Application Ref:	2025/0675			 Ribble Valley Borough Council www.ribblevalley.gov.uk
Date Inspected:	Various.	Site Notice:	25/09/2025	
Officer:	EP			
DELEGATED ITEM FILE REPORT:				APPROVAL

Development Description:	Proposed replacement roof structure including demolition of chimney stack to create two additional bedrooms and shower room and introduction of Juliet balcony to northern side gable.
Site Address/Location:	Holly House, 8 Station Road, Rimington BB7 4DR.

A4.2

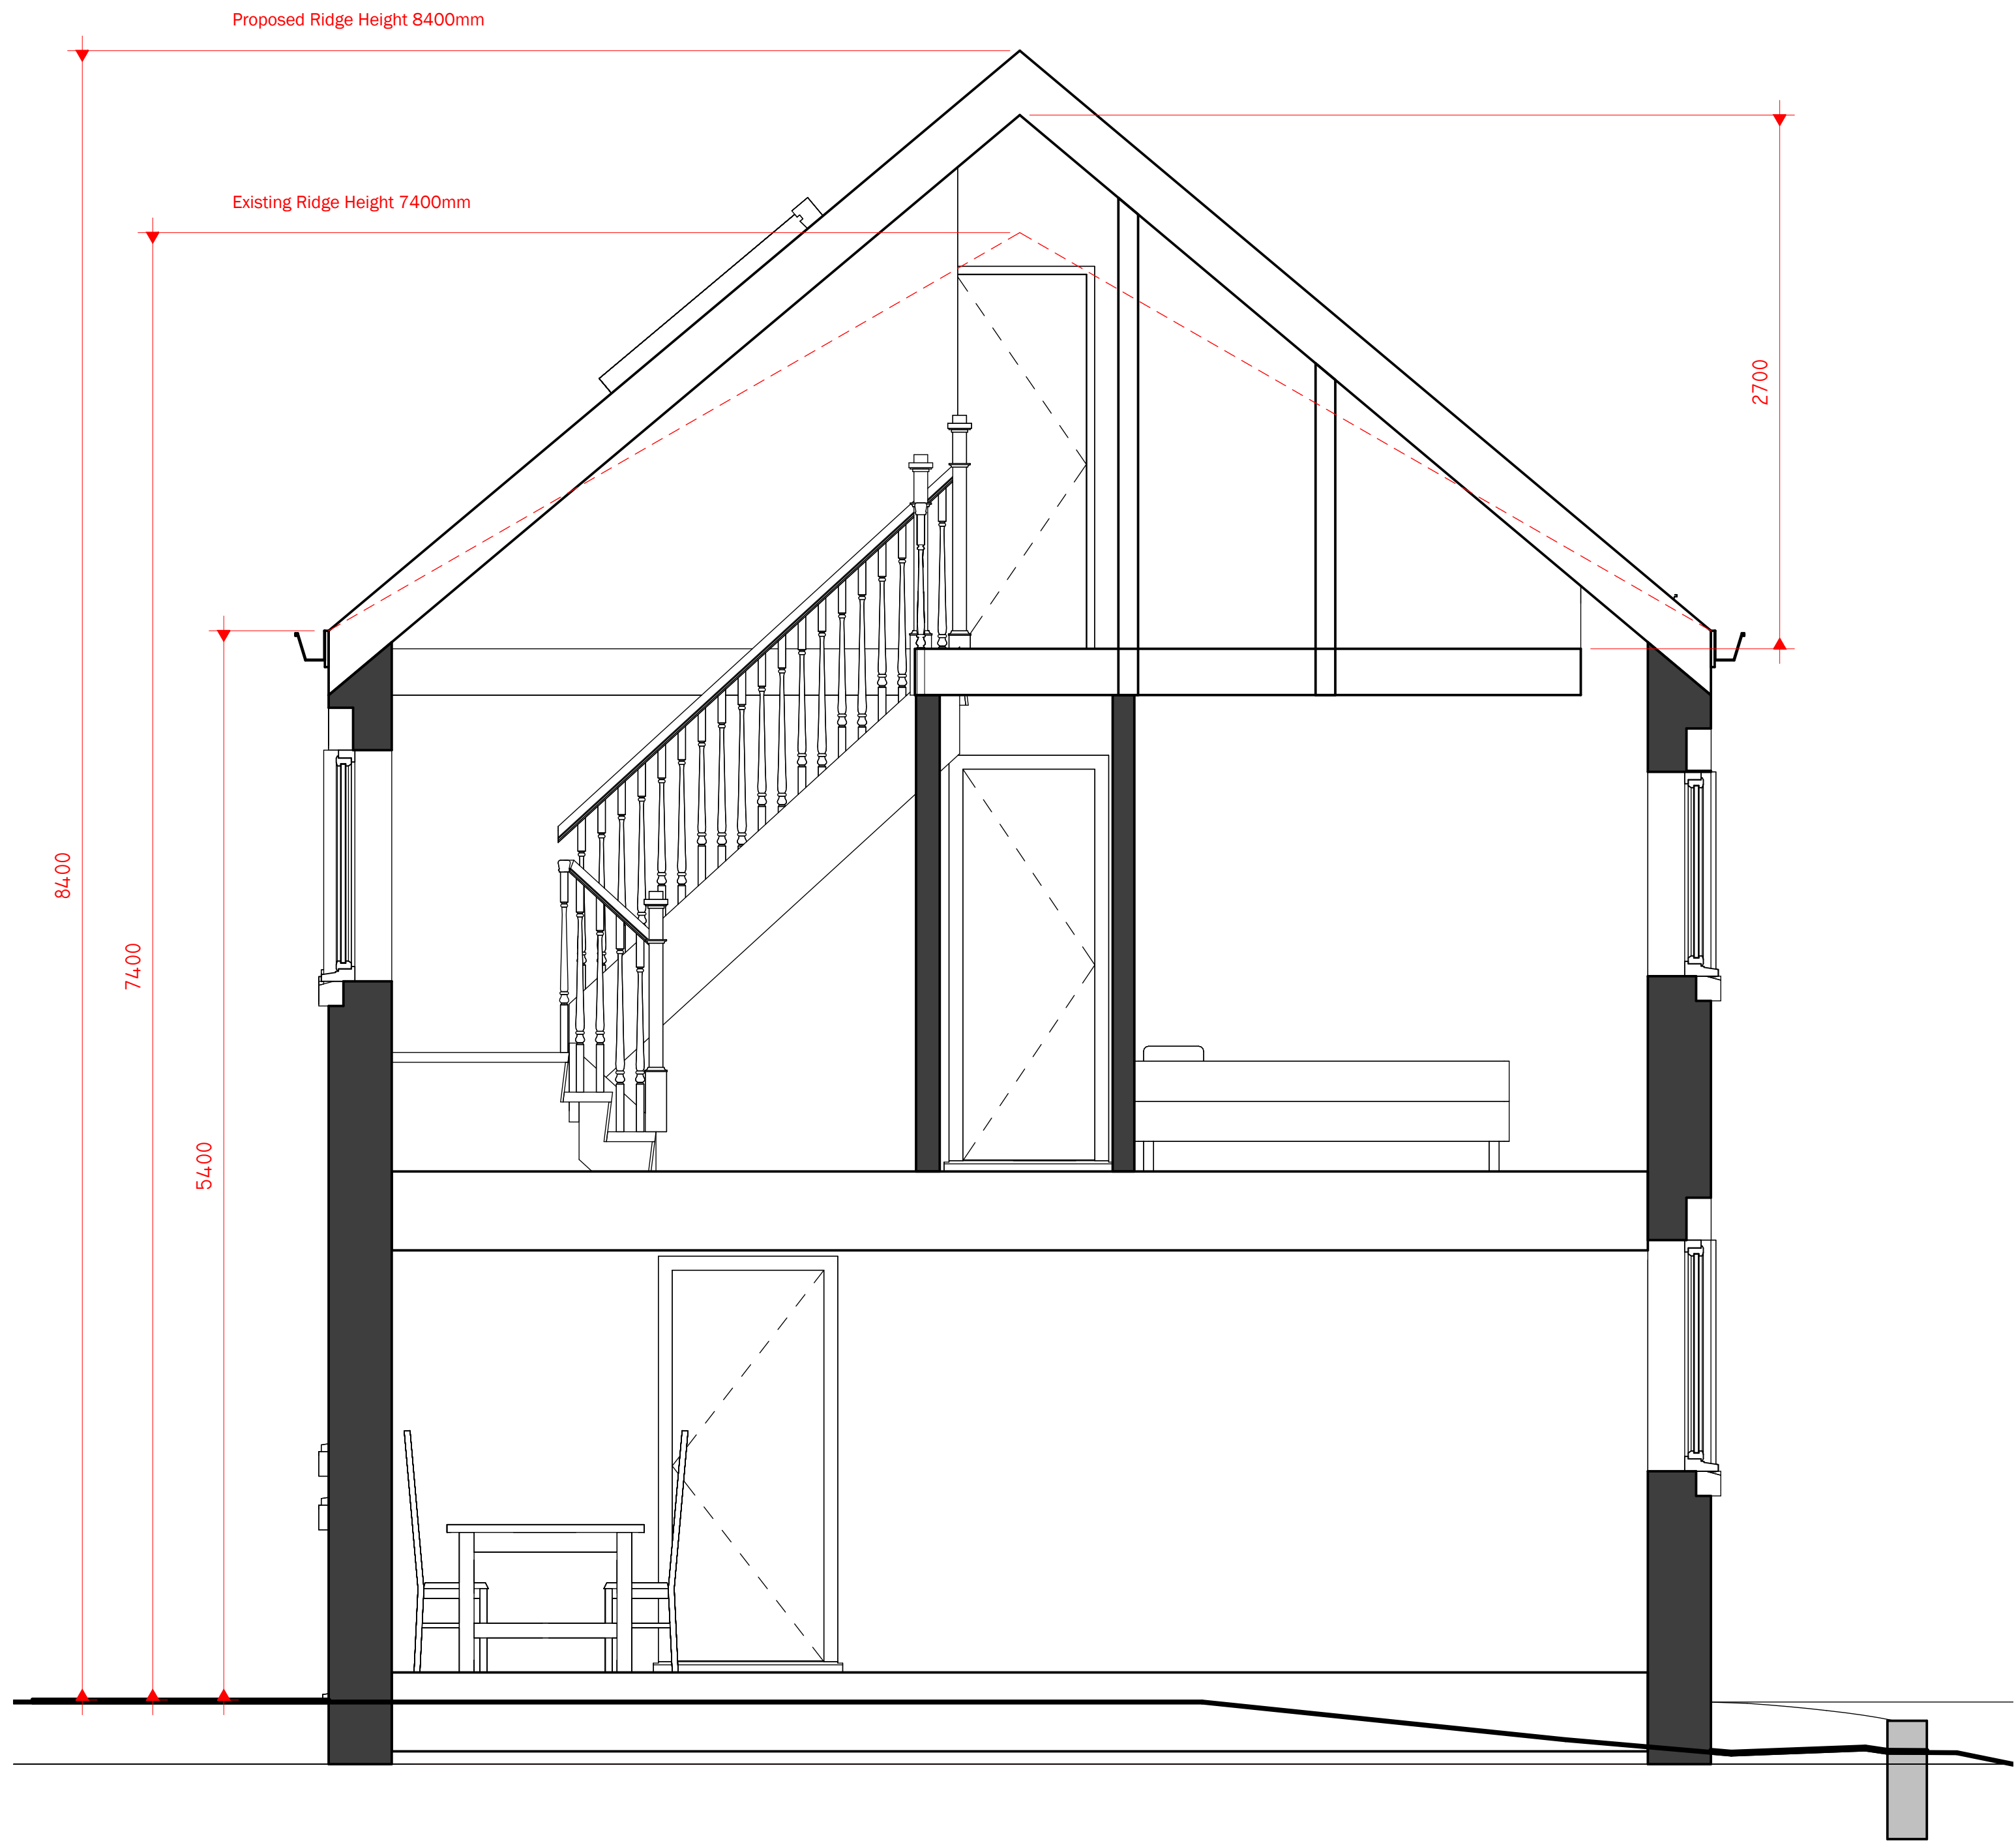
The existing roof slope is relatively shallow, as a result the roof will need to be heightened to accommodate additional storey living accommodation. The ridge will be increased by approximately 1m, given the shallow nature of the existing roof it is not considered that this alteration would look disproportionate or anomalous within the streetscape.
